**From:** Contact Centre (CRM) <contact@ribblevalley.gov.uk>  
**Sent:** 13 March 2024 13:06  
**To:** Planning  
**Subject:** Planning Application Comments - 3/2024/0067 FS-Case-595191248

**Planning Application Reference No.:** 3/2024/0067

**Address of Development:** 56 St Mary's Gardens BB2 7JP

1/200 SITE PLAN

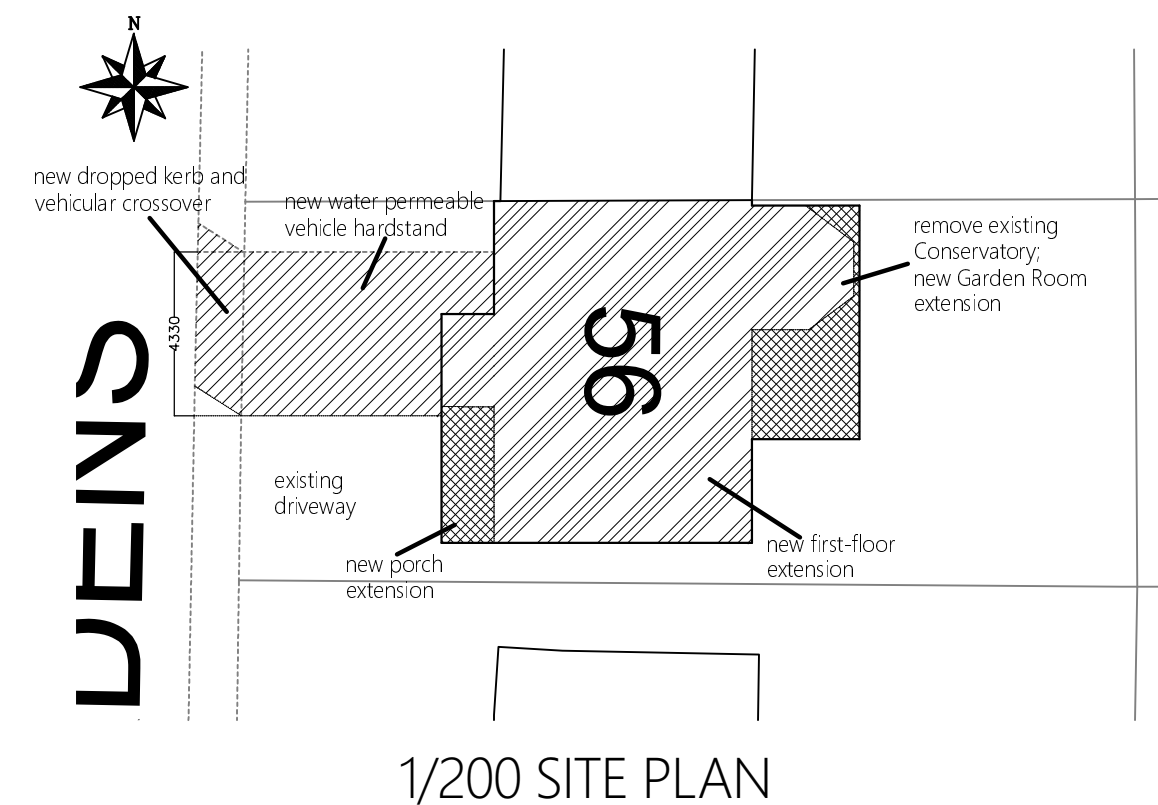
We would like the window on the ground floor side of the property to be frosted as this [REDACTED]  
[REDACTED] We would also like an extension of the fence line up to the existing gate with a height of 6ft, this is due [REDACTED]

**Comments:** We are supportive overall of the development, however would like to request some mitigation to privacy concerns. We would like to request the ground floor window at the side of the development is installed with privacy/frosted glass. As this is close to [REDACTED] [REDACTED] is extended up to the existing gate with at least 6ft height ([REDACTED])  
This is to ensure privacy is maintained as the [REDACTED]

GROUND FLOOR PLAN

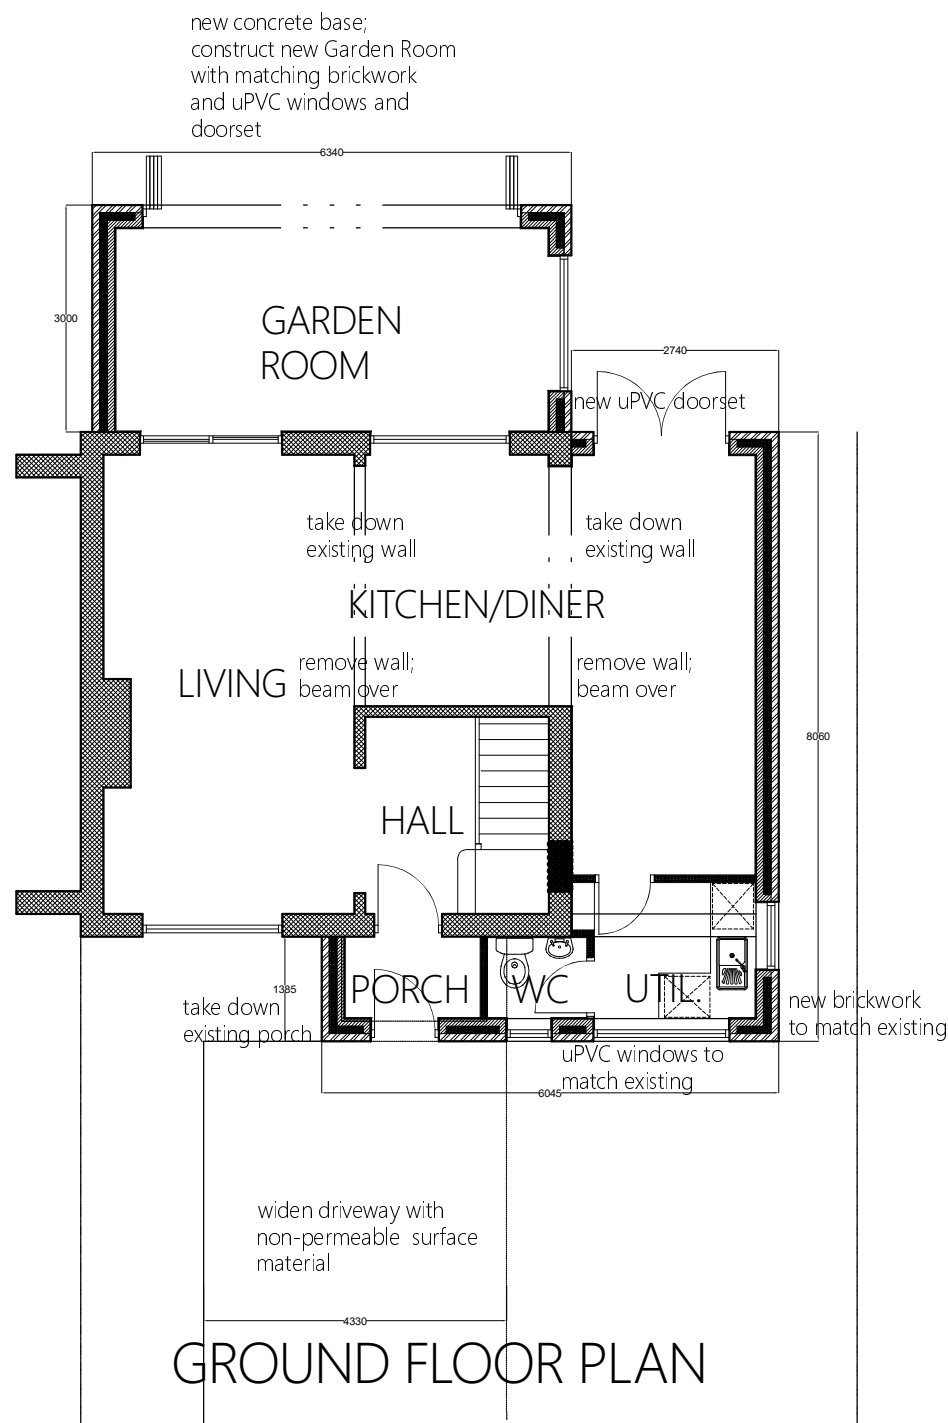
**Comments:** I submitted a previous response but an error when I pressed submit so here is another. We are overall supportive of the application however would like some mitigations put in place to support privacy.
